Address: 45 Park Road Huddersfield Hd4 5db

Application number: 2023/92671	
What is the application for?:	Raising of roof and eaves of the dwelling to create first floor and new roof wi
Address of the site or building:	47, Park Road, Crosland Moor, Huddersfield, HD4 5DB
Postcode:	HD4 5DB

Proposed Roof Plan Scale 1:100 (Ref: HD45DB47)

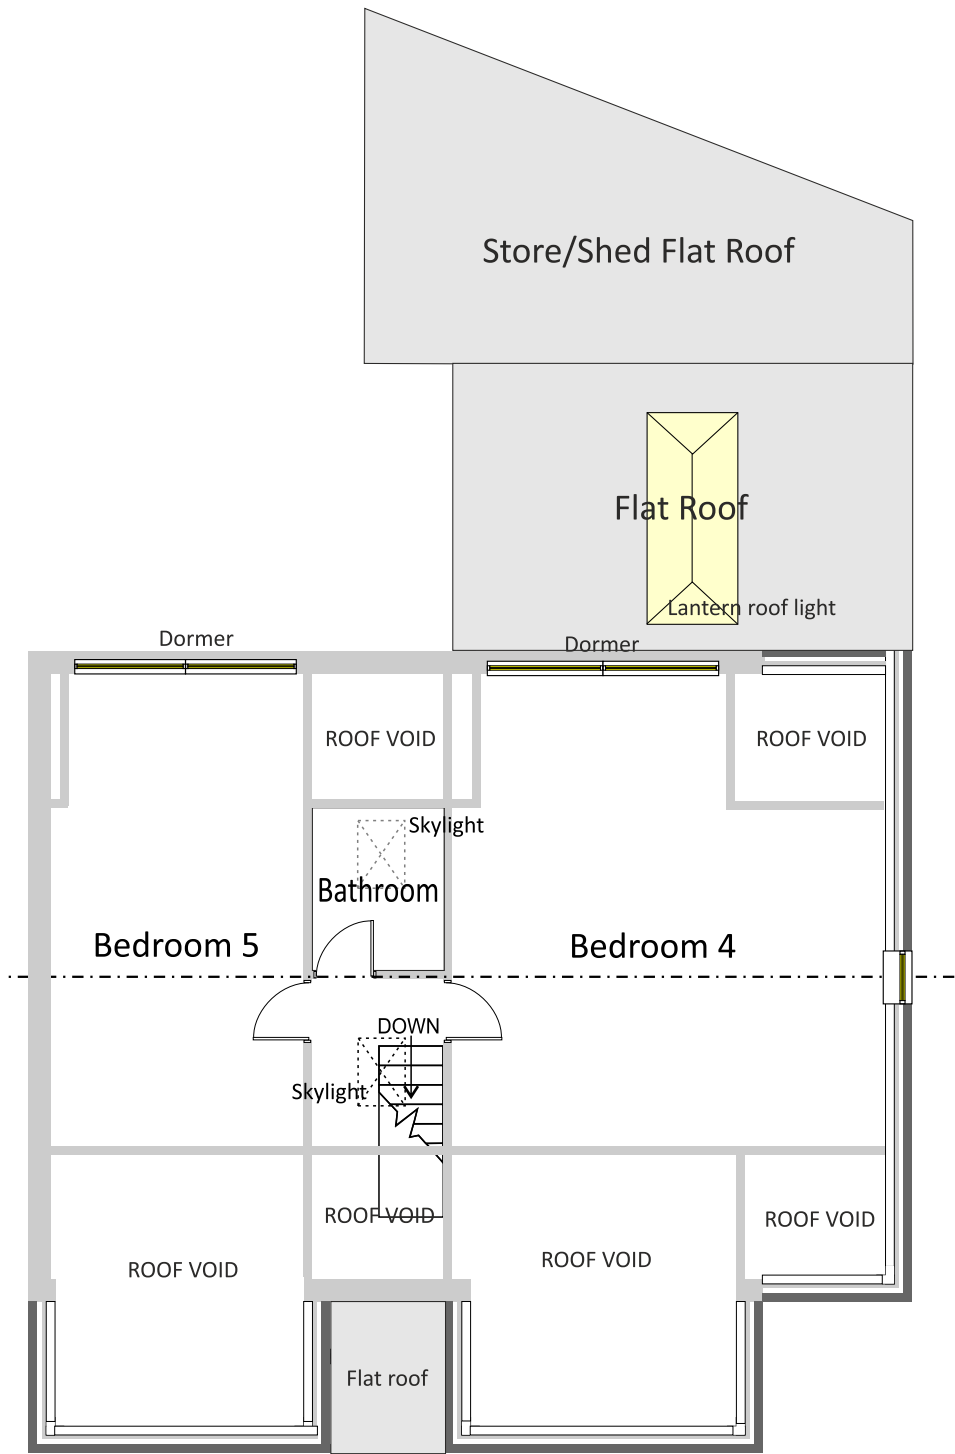
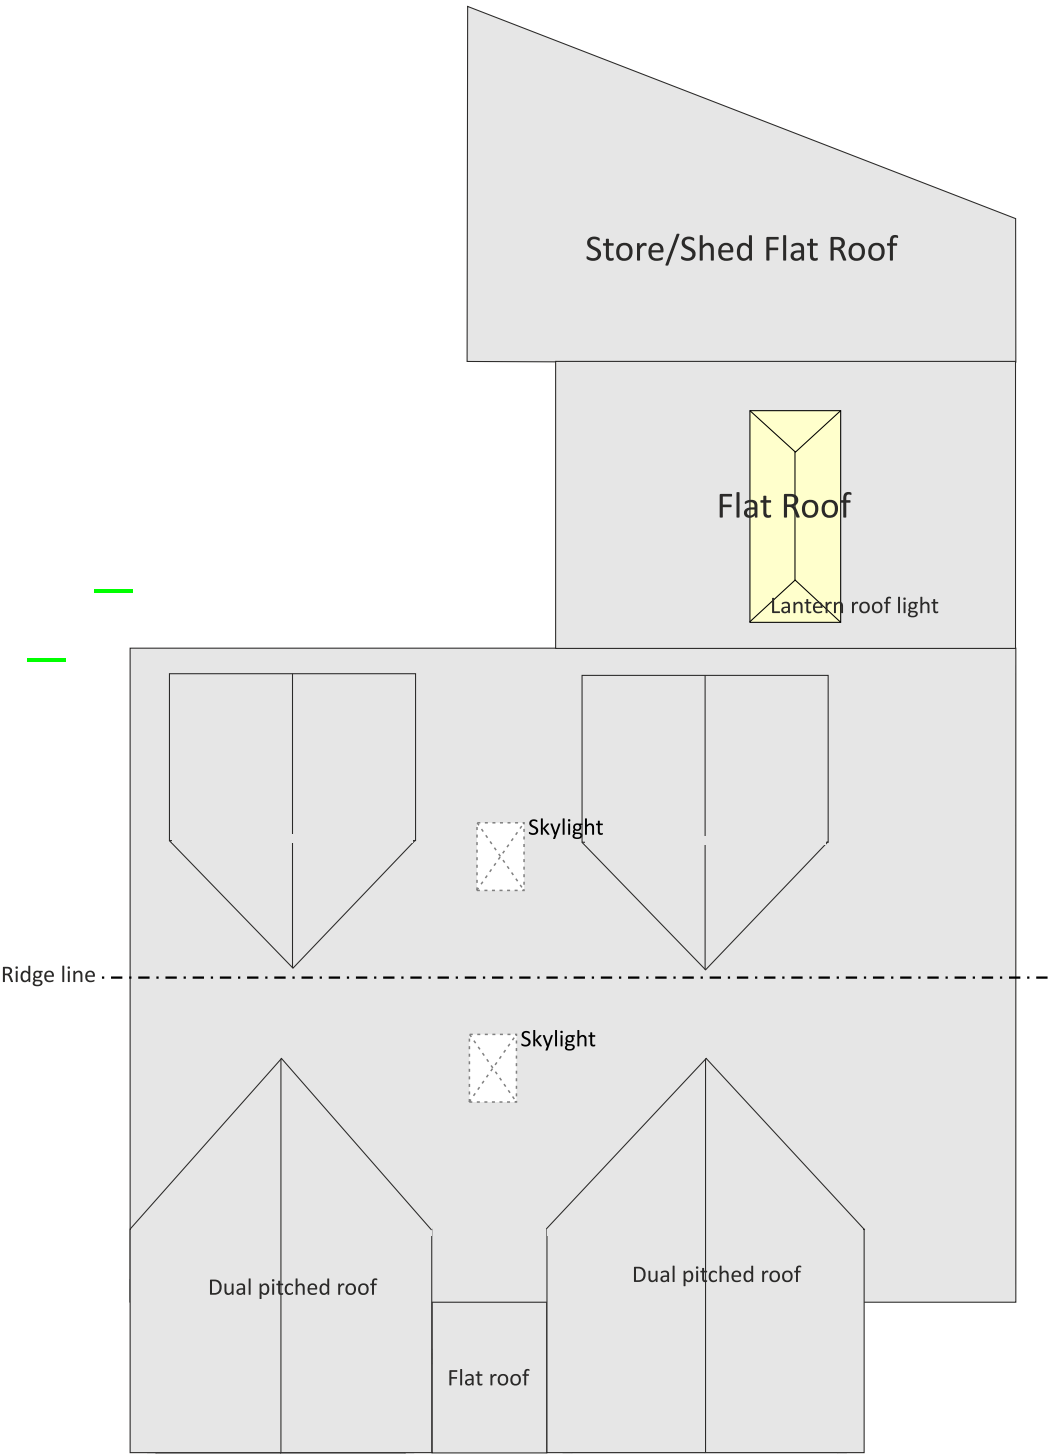
Type of comment: An objection	
Do you wish your comments to be published on the website anonymously?	No
Firstly we are raising objections to planning extension namely rear dormer roof , which we believe to be set too high to roof ridge level, it would affect our natural light and view from our two side gable bedroom windows We have similar situation to our opposite gable due to adjacent property. Thus feel the the dormer should be set lower to ridge level to to reduce impact on our property. Second point regarding new access to driveway from park Road. We don't feel there is any need for new vechicle access from Park Road, as there is an existing drive access from Evevard Street which would be widened in the plans this would more than ample space for parking. This would affect congestion and flow of traffic on park Road.We have issues at present accessing our driveway, due to high traffic flow and having adjacent new access would cause more problems with vehicles and also affect pedestrians. It would also affect the local street view, we would like to retain some character this our locality,and don't want to see new car showroom. We would like to see proportional and sensible development , and in keeping with local street view and environment. I refer to previous extensions to banglows in the same area ,Lightcliffe Road.Which have been appropriate and subtable development and retained some character of previous structure and street view. We hope you take our views in consideration .
